DORAN DRIVE PRECINCT SHOWGROUND

RESPONSE TO STATE DESIGN REVIEW PANEL - MEETING 3

DEICORP PROJECTS (SHOWGROUND) PTY LTD

Please find below a summary of detailed response prepared by the project team to address the items raised in the letter dated 19th November 2021 by State Design Review Panel. State Design Review Panel meeting was held on 10th November 2021.

3.15 LEVEL 9 PLAN

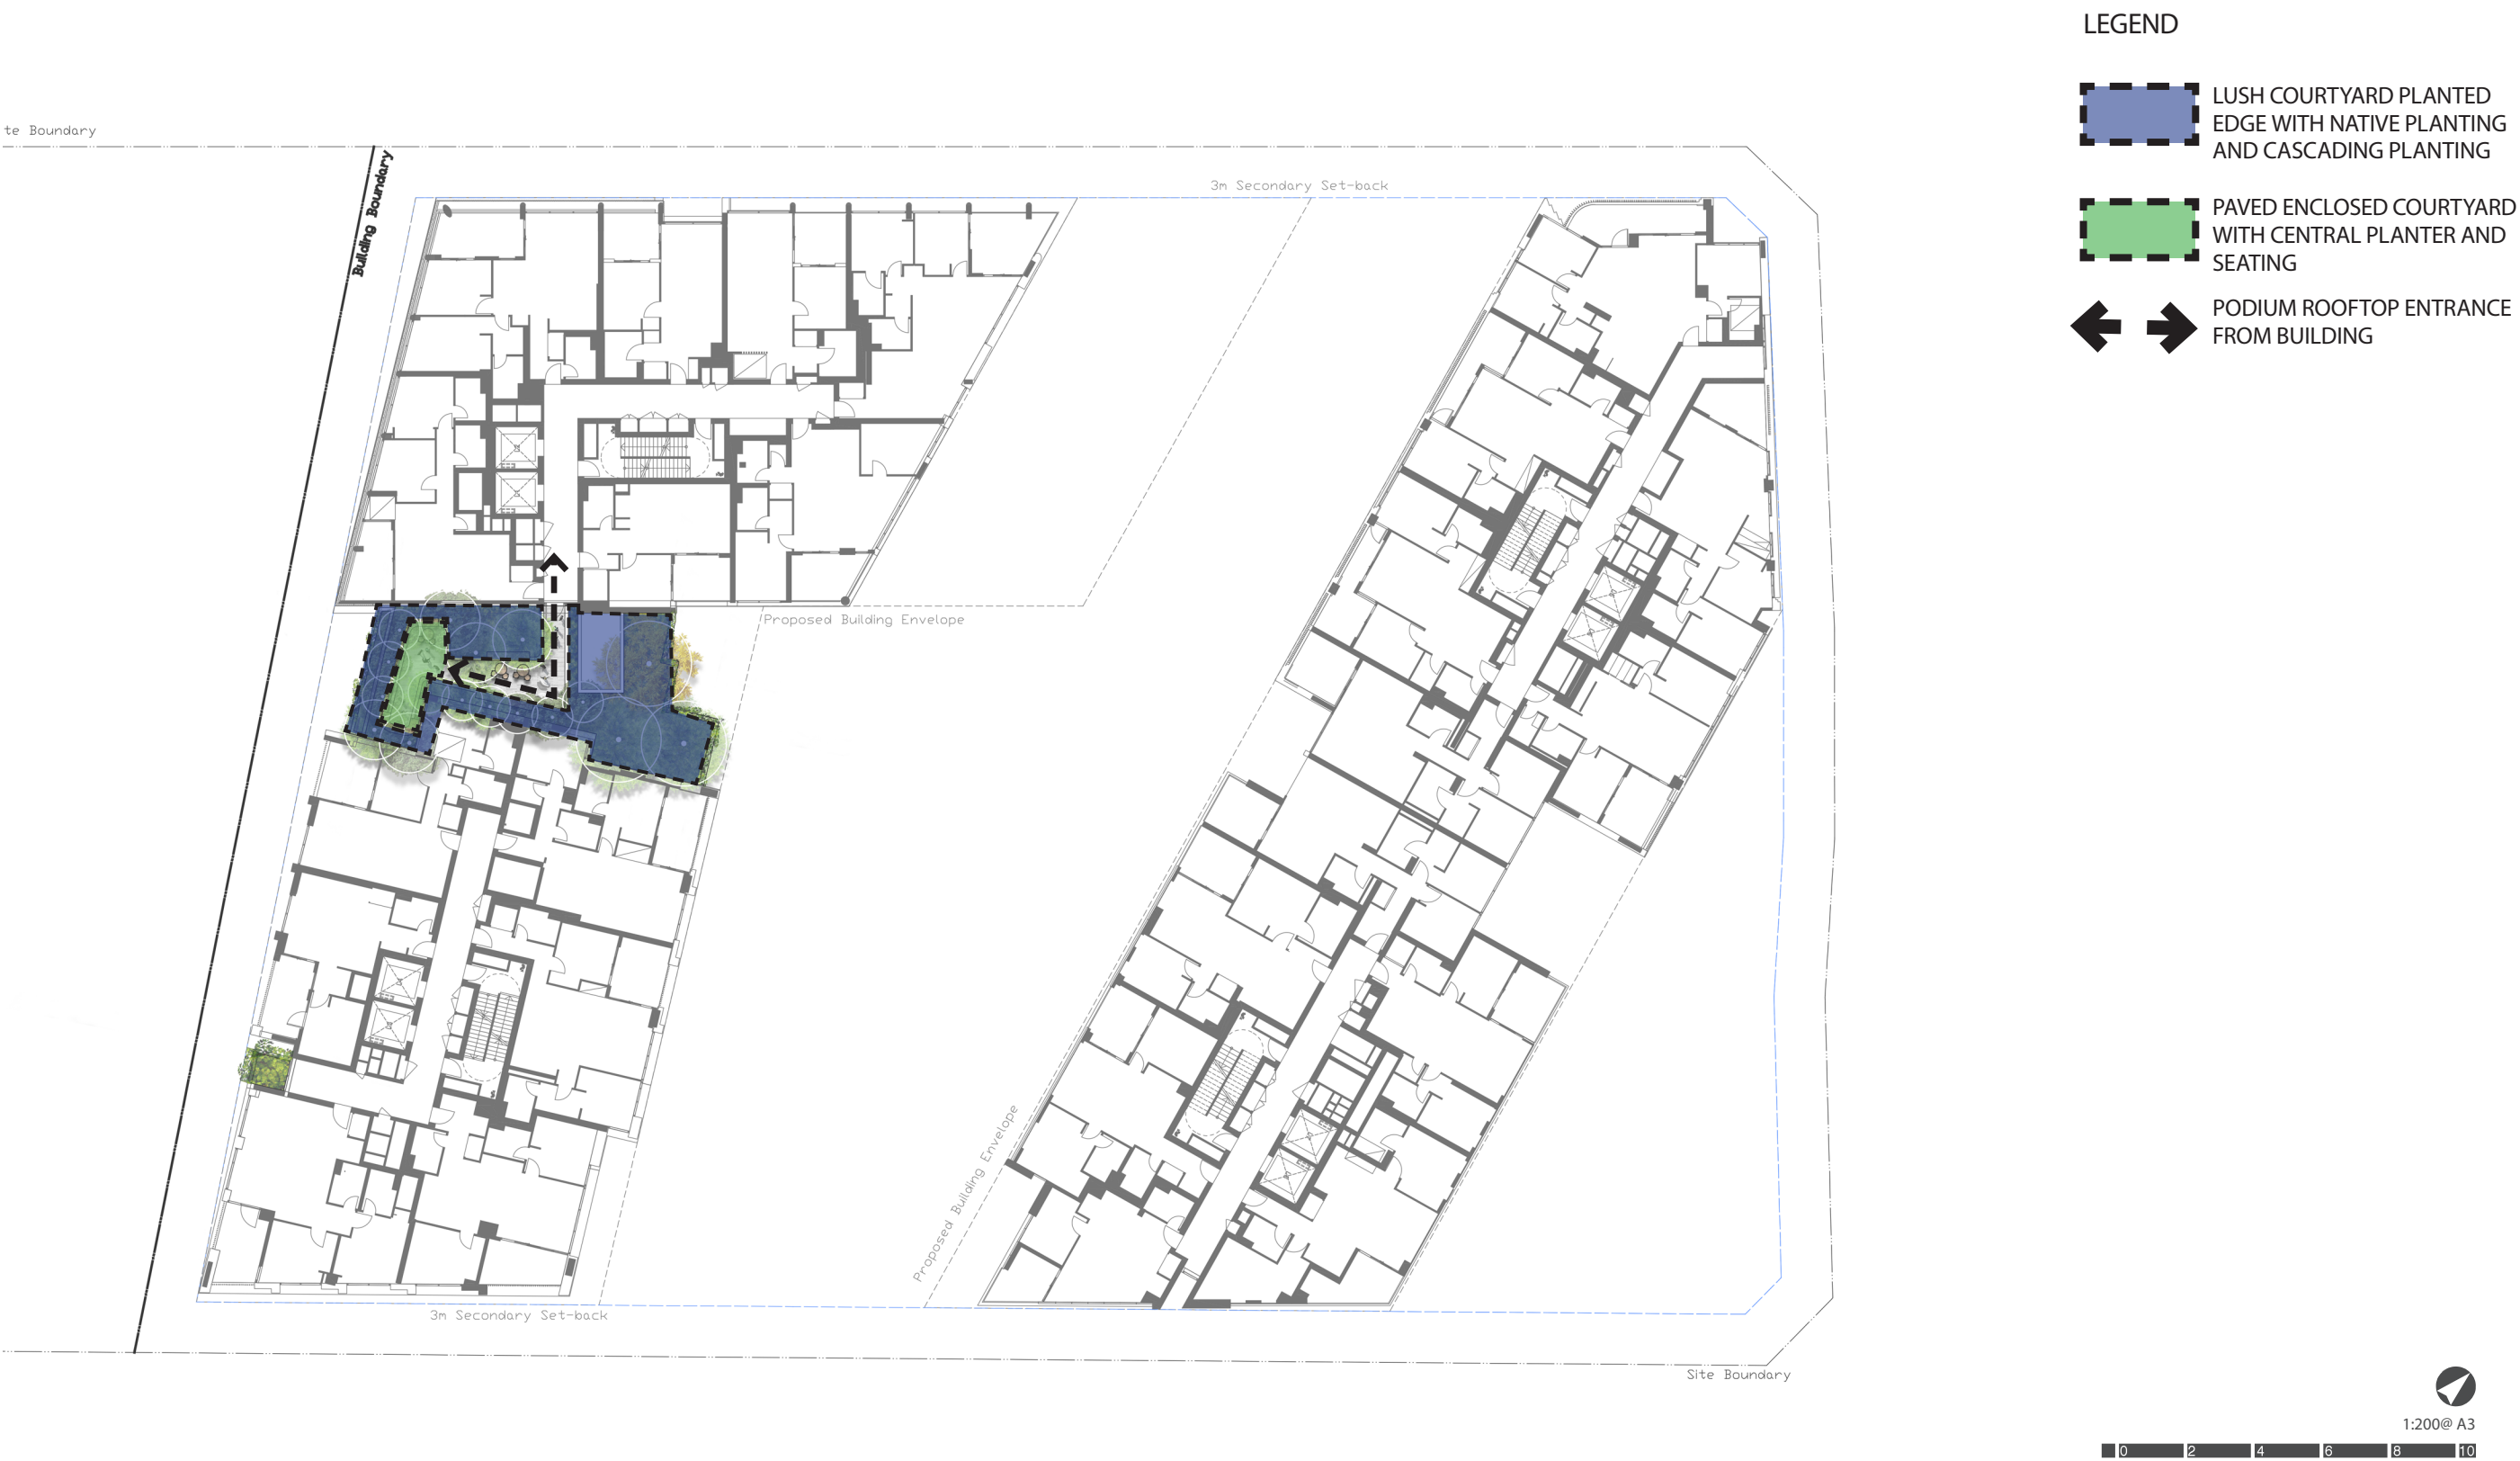
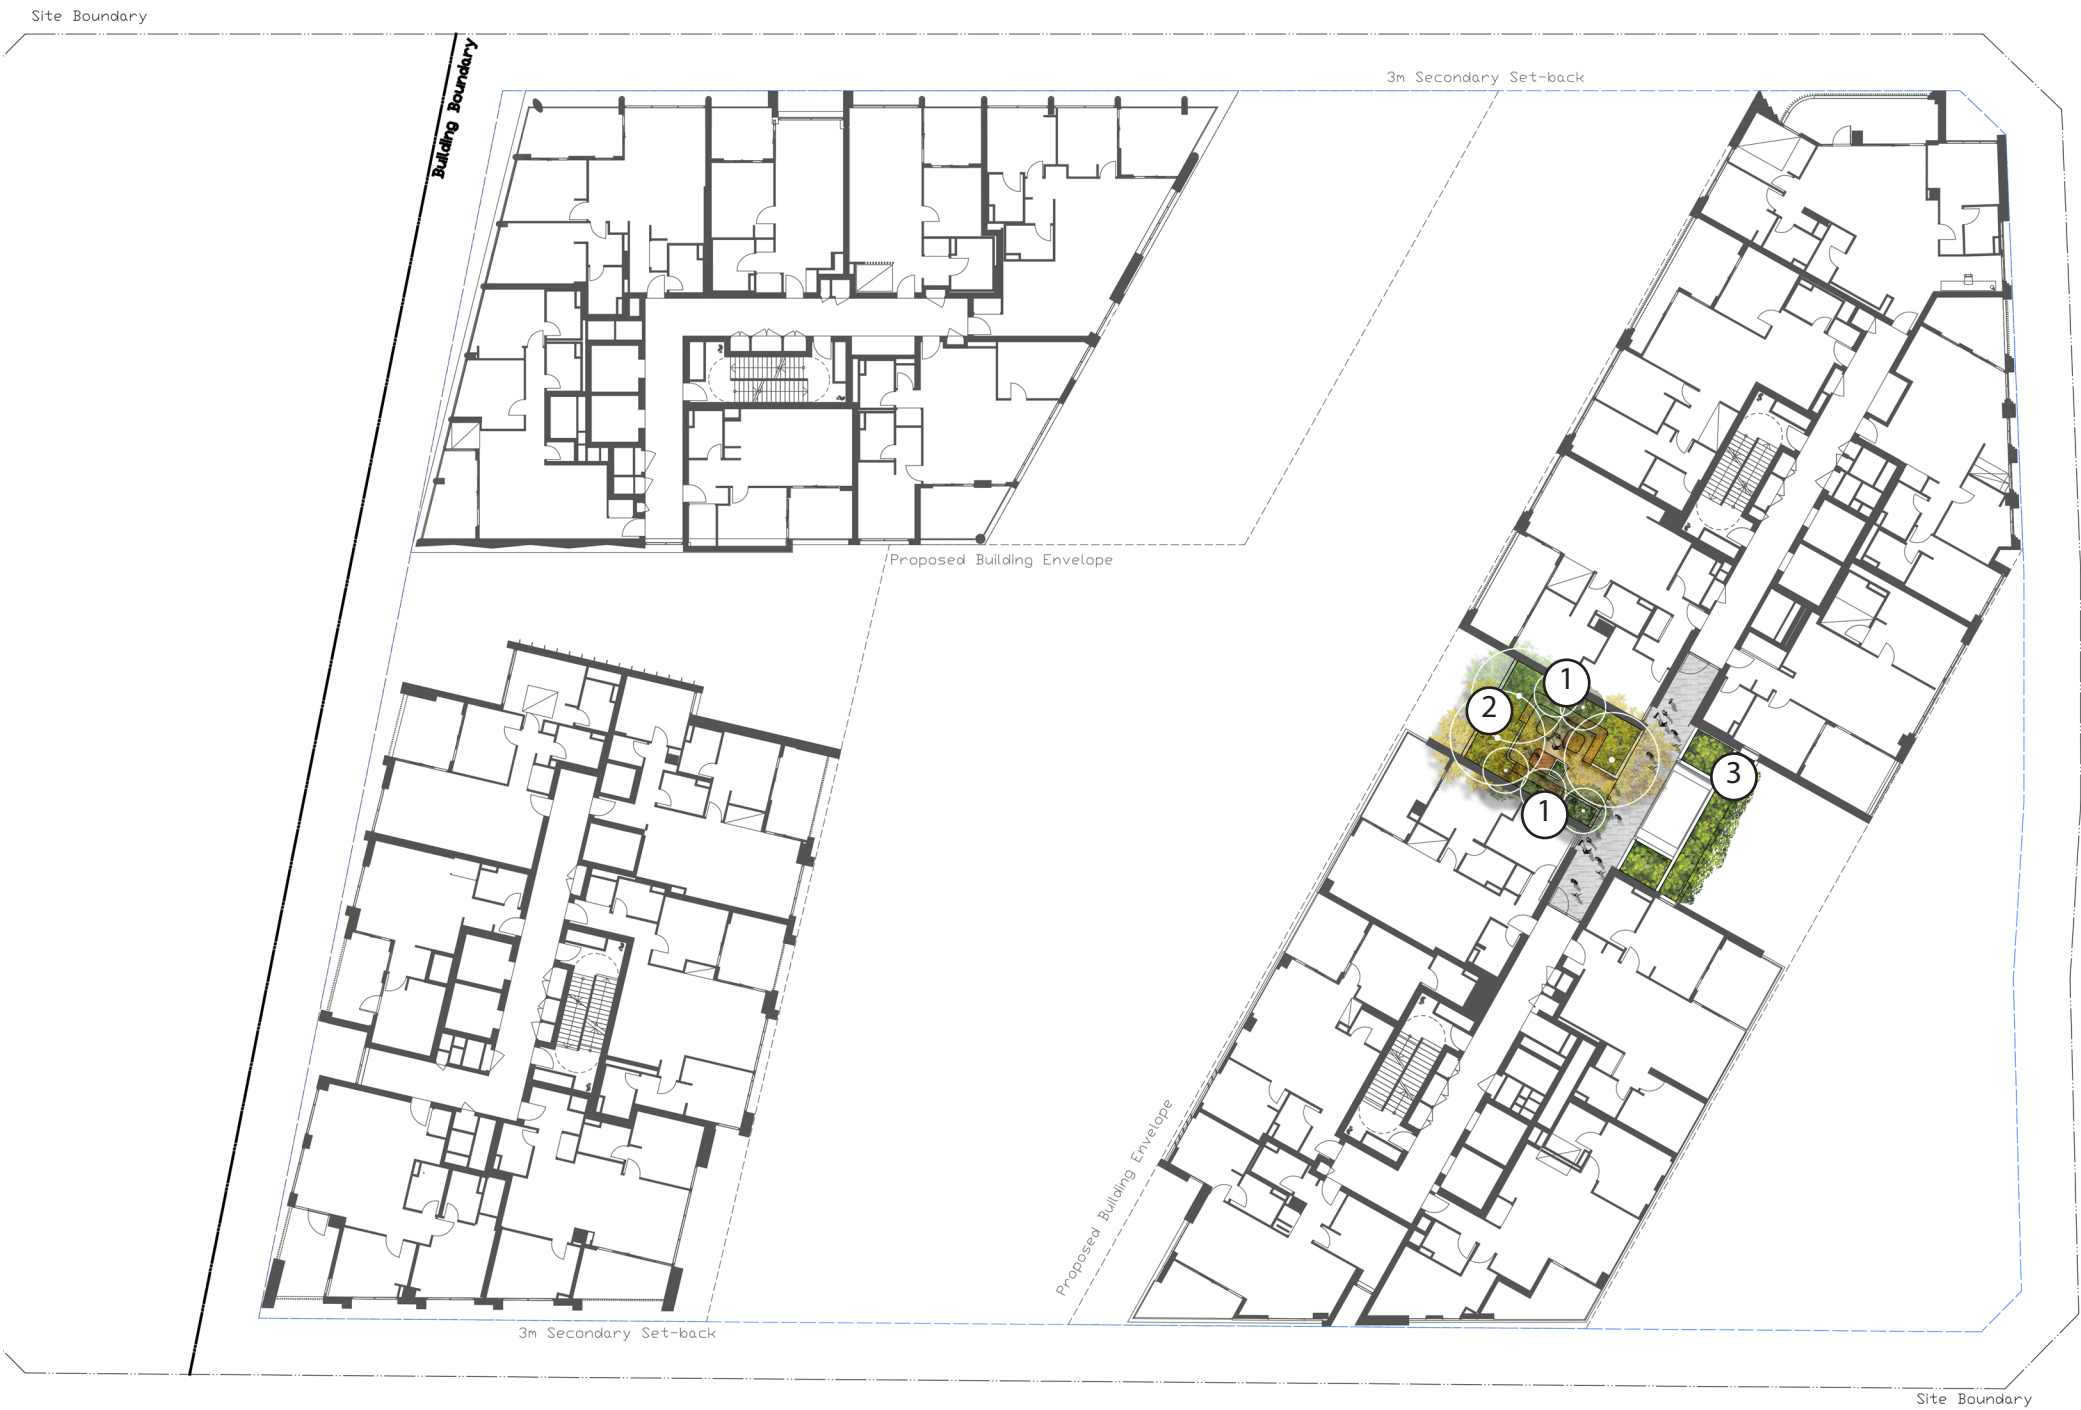
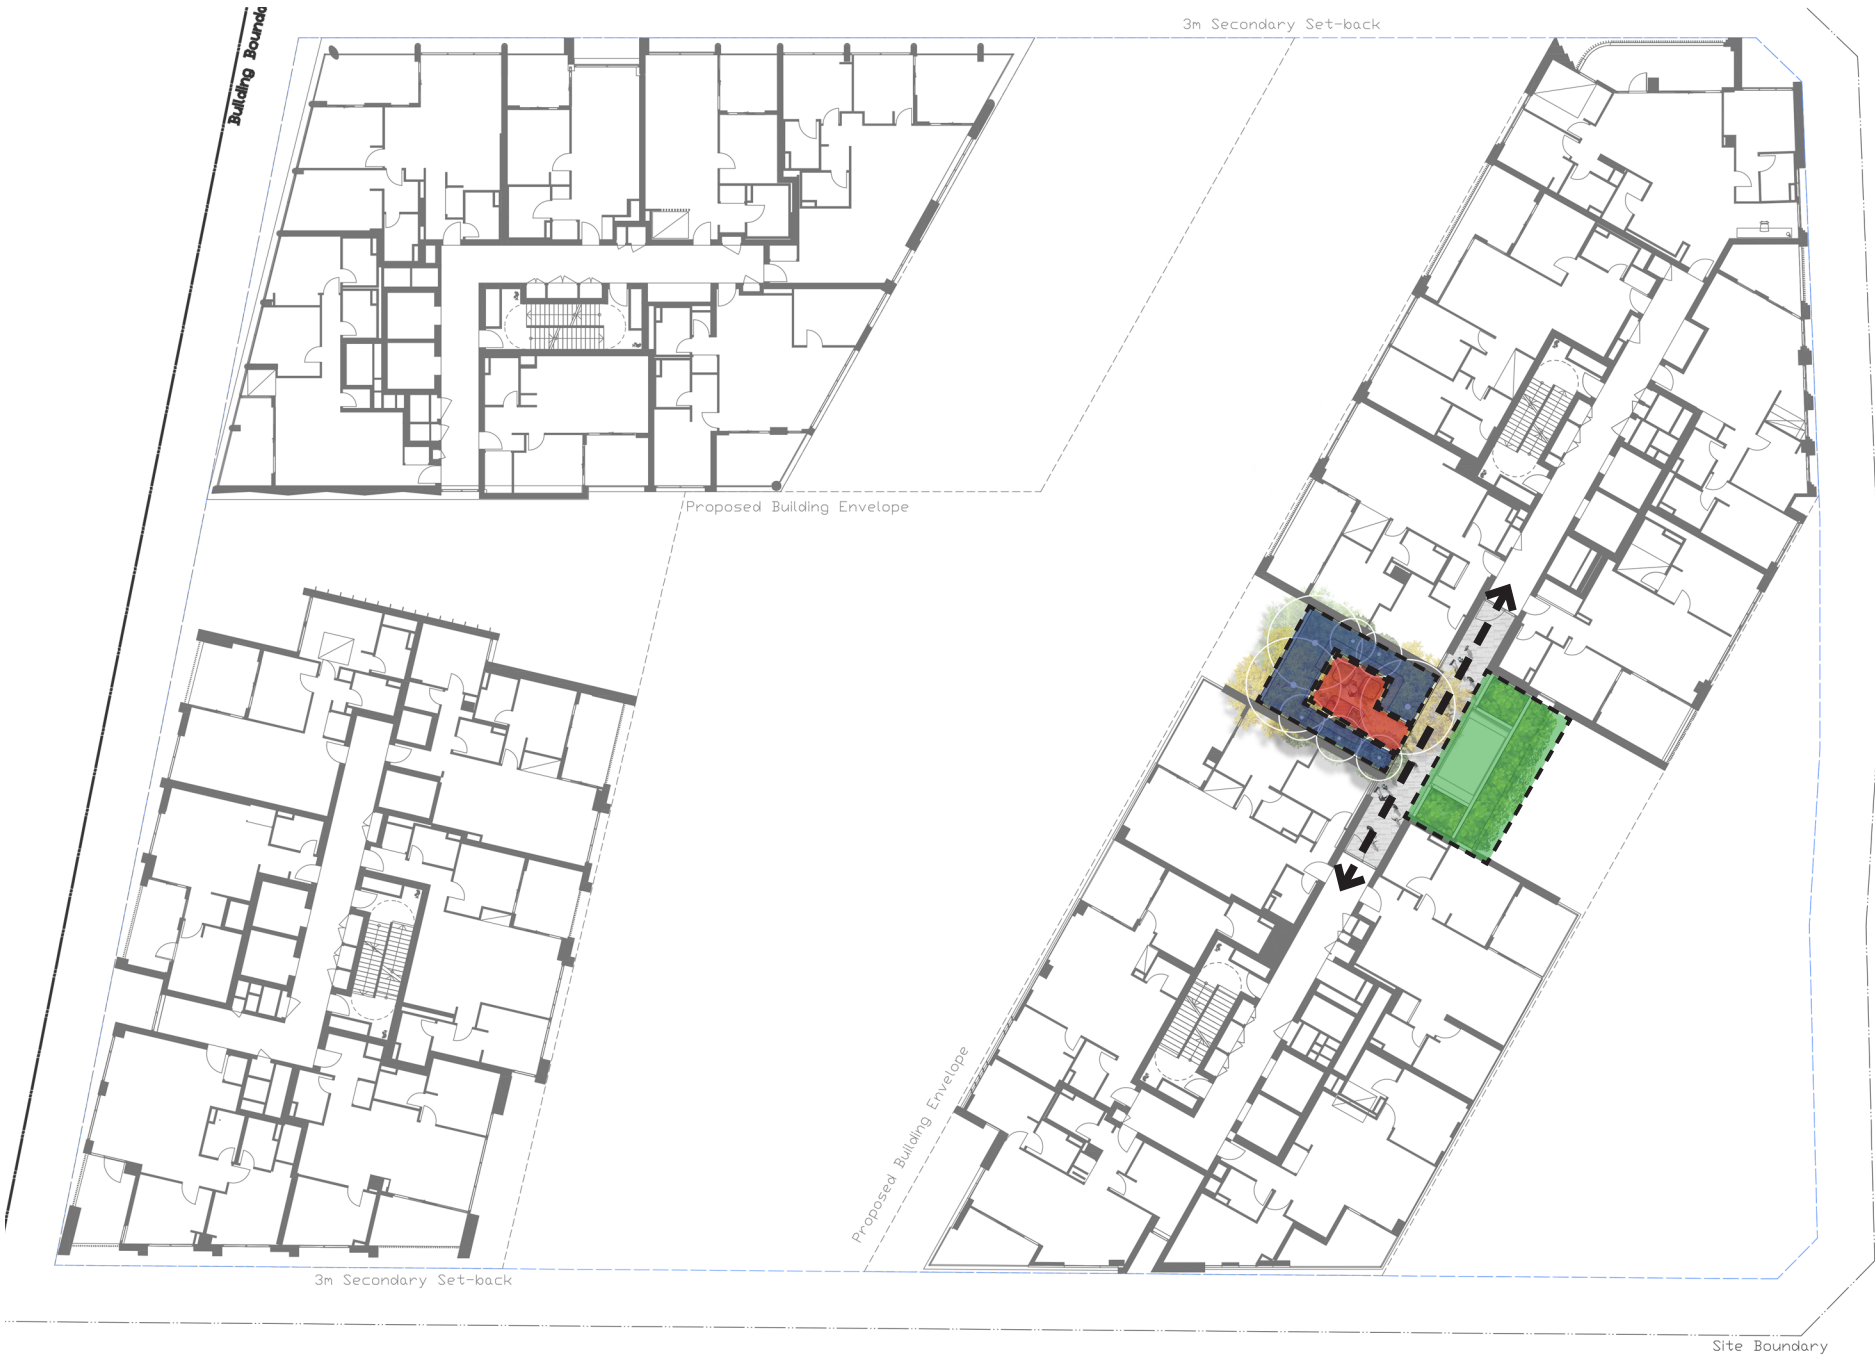
<ul style="list-style-type: none"> • Illustrate the types and quality of landscape spaces, planting, seating and intended activities. 	<p>Urbis Mark Kuhne Director / Registered Landscape Architect #1226 (AILA)</p>	<p>Doran Drive Plaza forms a key piece of open space between the Metro Station and the Castle Hill Showground. The 1,400m² plaza space is bounded by Doran Drive to the west, De Clambe Drive to the north, Mandala Parade to the south and built form to the east.</p> <p>The Plaza is intended to be a high quality, flexible urban open space that functions both as a permeable connection between the station, buses, retail and the Castle Hill Showground, as well as providing an activated and comfortable space for people to use and inhabit day to day.</p>  <p>3D view illustrates the intended activities, planting, materiality and seating</p> <p>Refer to item 1 response for further illustration on all proposed landscaping spaces including Doran Drive Plaza and communal open spaces.</p> <p><u>SITE WIDE PLANTING STRATEGY</u></p> <p>The site wide plant strategy has been inspired by the adjacent Fred Caterson Reserve and bushland types and communities.</p>  <p>Reference – 'The bushland of Fred Caterson Reserve' Baulkham Hills Shire Council 2007</p>

<ul style="list-style-type: none"> • To eliminate the use of noxious weeds of potentially invasive species in the development • To use plants in such a way to foster energy efficient development that relies on passive energy principles for heating and cooling • To reduce maintenance and water consumption through appropriate species selection • To create buffer zones and add to existing areas of remnant vegetation with locally indigenous species including supplementary River-Flat Eucalypt Forest on Coastal Floodplains planting. • The Landscape planting for the site will have a minimum of 75% of indigenous / water sensitive planting species. <p>The plant palettes developed for the site reinforces the environmental theme, that the planting palette is drawn from existing local vegetation communities. In general, street trees should respond to the street hierarchy and Council's street tree list.</p> <p>The following list outlines the signature planting for the site and has been established with reference to:</p> <ul style="list-style-type: none"> • Hills shire DCP 2012: Section C3- Landscape • Office of Environment and Heritage: River-flat Eucalypt Forest on Coastal Floodplain - species list • The bushland of Fred Caterson Reserve - Bushland Reserves - vegetation communities plant list <p>The ground level Doran Drive Plaza is proposed to integrate the Sydney Sandstone Gully Forest and Sydney Sandstone Ridge Top Woodland.</p> <p>Level 2 and 3 podium / rooftop is proposed to integrate the Shale / Sandstone Transition Forest.</p> <p>Level 8 and Level 9 is proposed to integrate the Sydney Turpentine Ironbark Forest.</p>
